ENG-SF21033-R4-CDs.pdf Markup Summary

WP01 PROFILE (1)
STA 33+50.00 TO 44+50.00

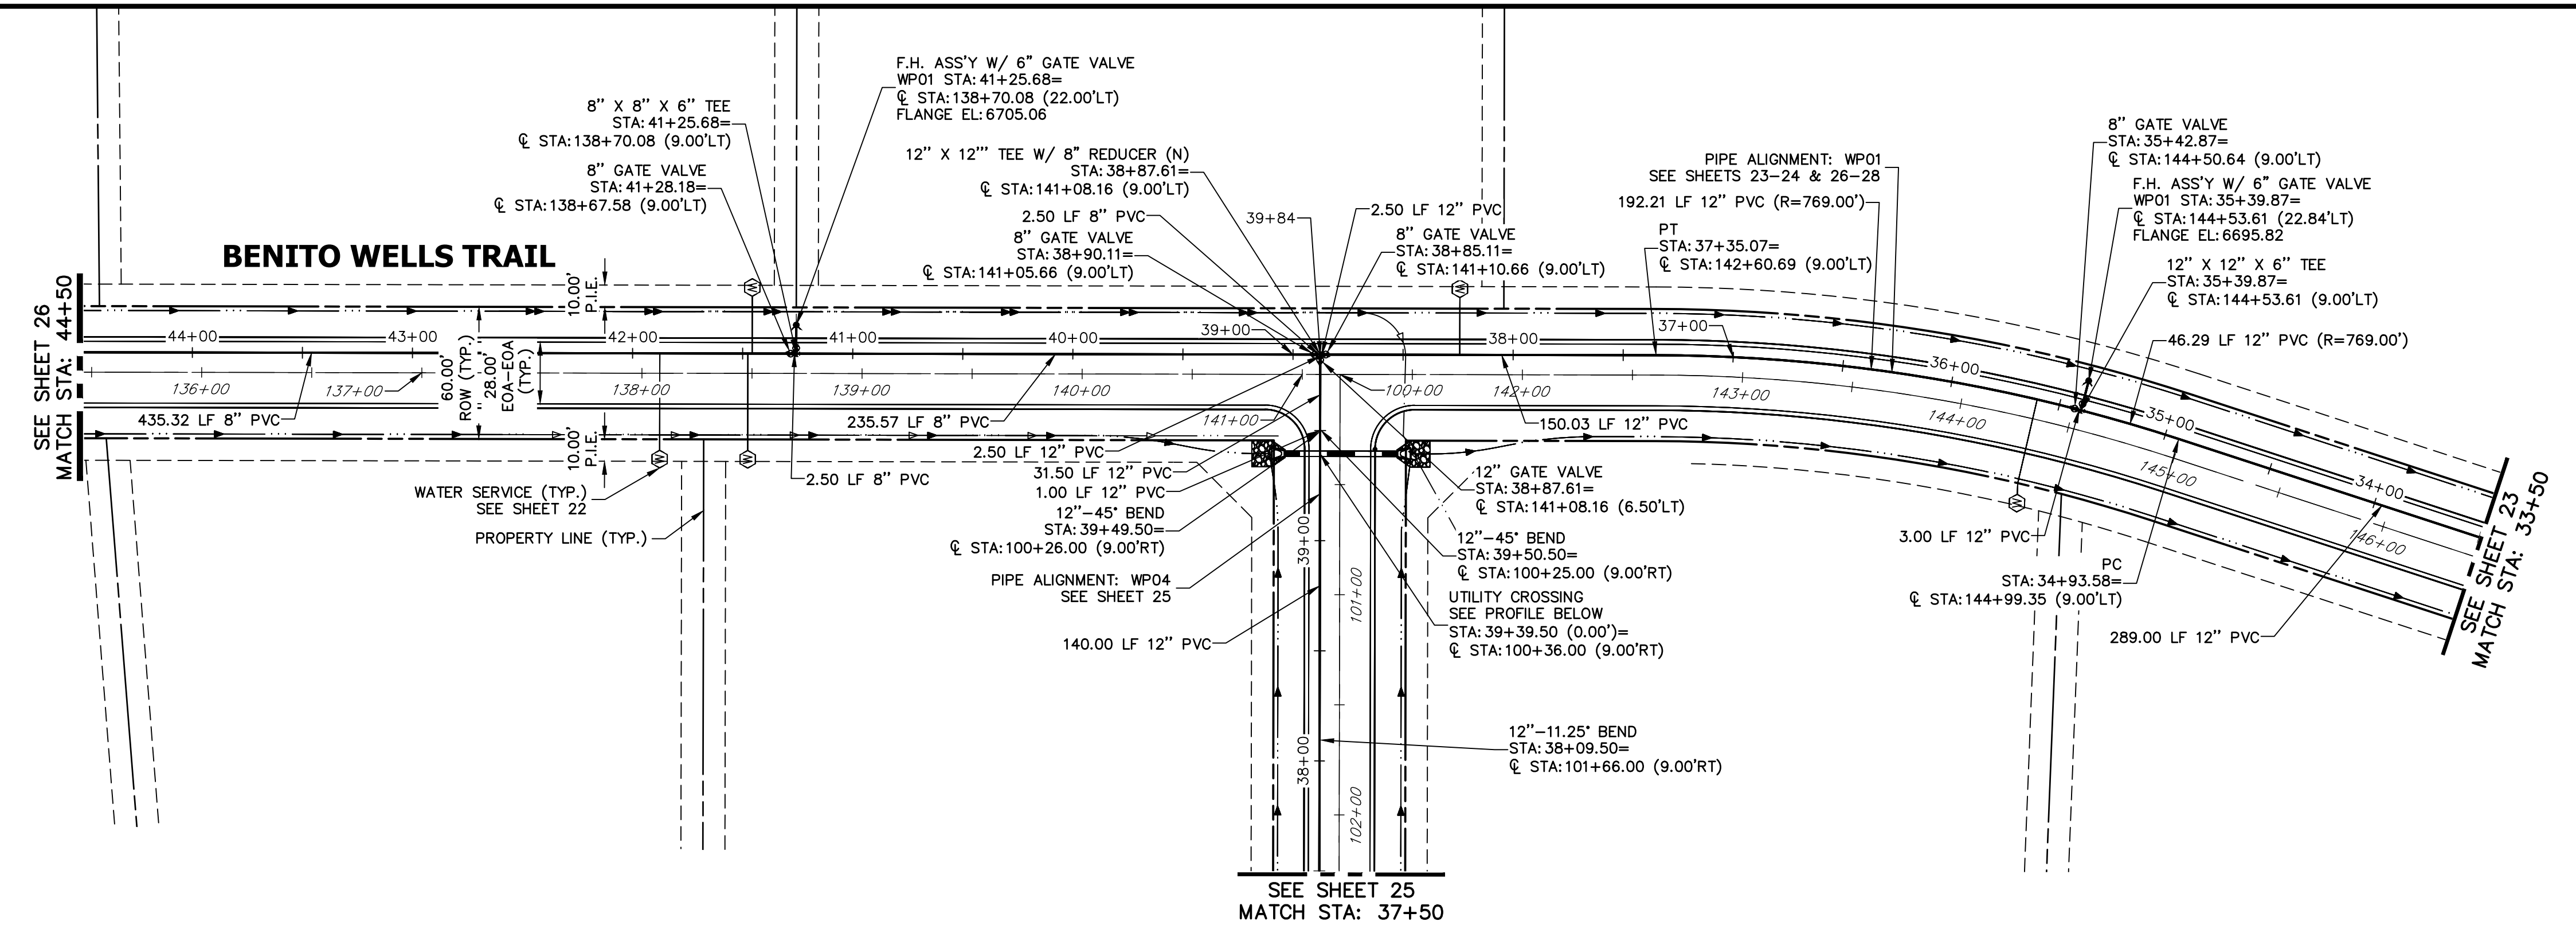
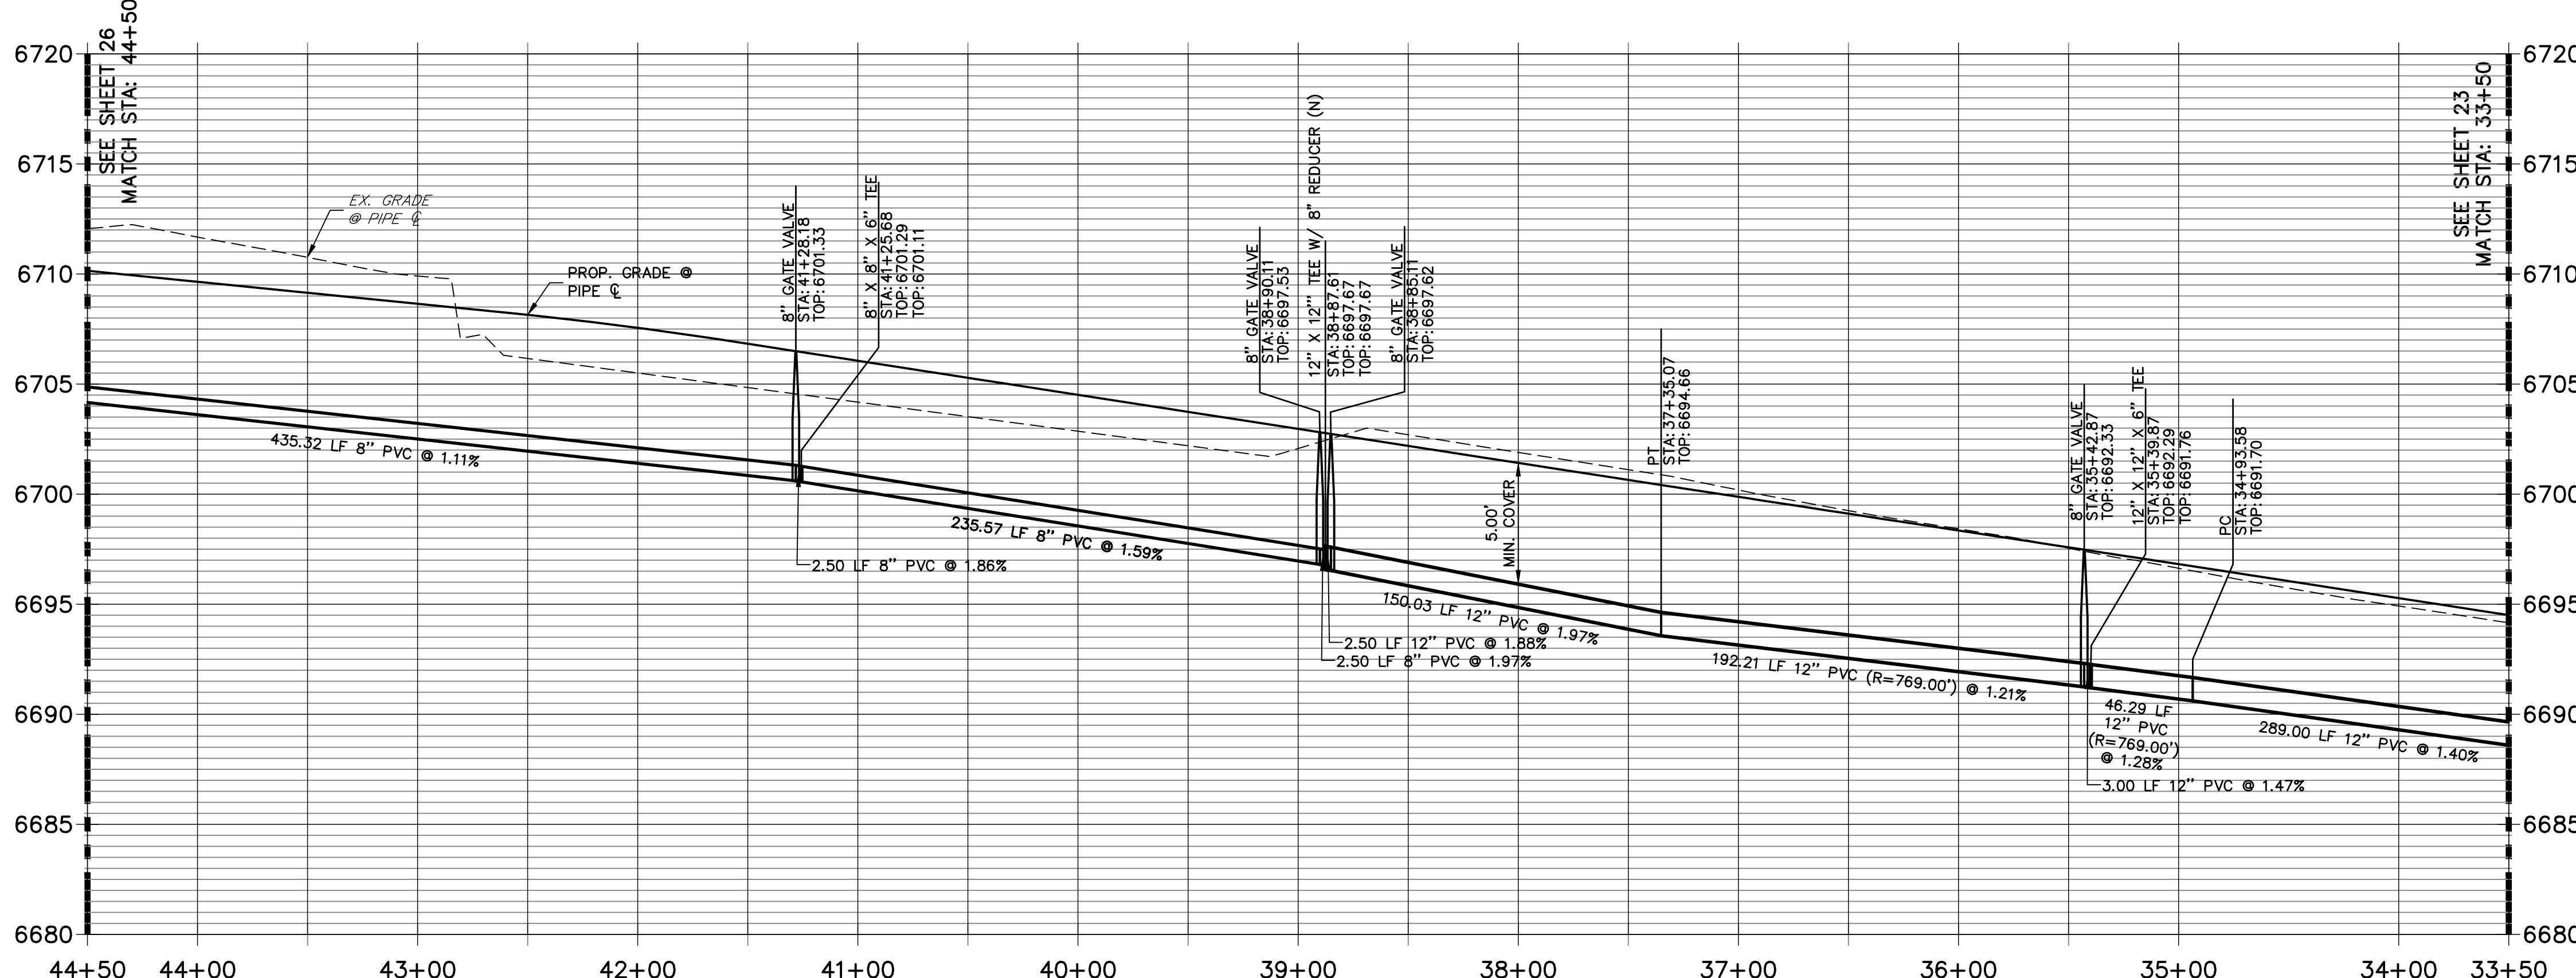
Subject:
Page Index: 23
Date: 1/6/2023 2:18:31 PM
Author: dsdrice
Color: ■
Layer:
Space:
Page Label: [24] 24 WP01 (1)

Subject:
Page Index: 23
Date: 1/6/2023 2:18:35 PM
Author: dsdrice
Color: ■
Layer:
Space:
Page Label: [24] 24 WP01 (1)

Subject:
Page Index: 23
Date: 1/6/2023 2:18:50 PM
Author: dsdrice
Color: ■
Layer:
Space:
Page Label: [24] 24 WP01 (1)

Subject:
Page Index: 23
Date: 1/6/2023 2:18:53 PM
Author: dsdrice
Color: ■
Layer:
Space:
Page Label: [24] 24 WP01 (1)

Subject:
Page Index: 23
Date: 1/6/2023 2:19:15 PM
Author: dsdrice
Color: ■
Layer:
Space:
Page Label: [24] 24 WP01 (1)

Subject:
Page Index: 23
Date: 1/6/2023 2:19:37 PM
Author: dsdrice
Color: ■
Layer:
Space:
Page Label: [24] 24 WP01 (1)
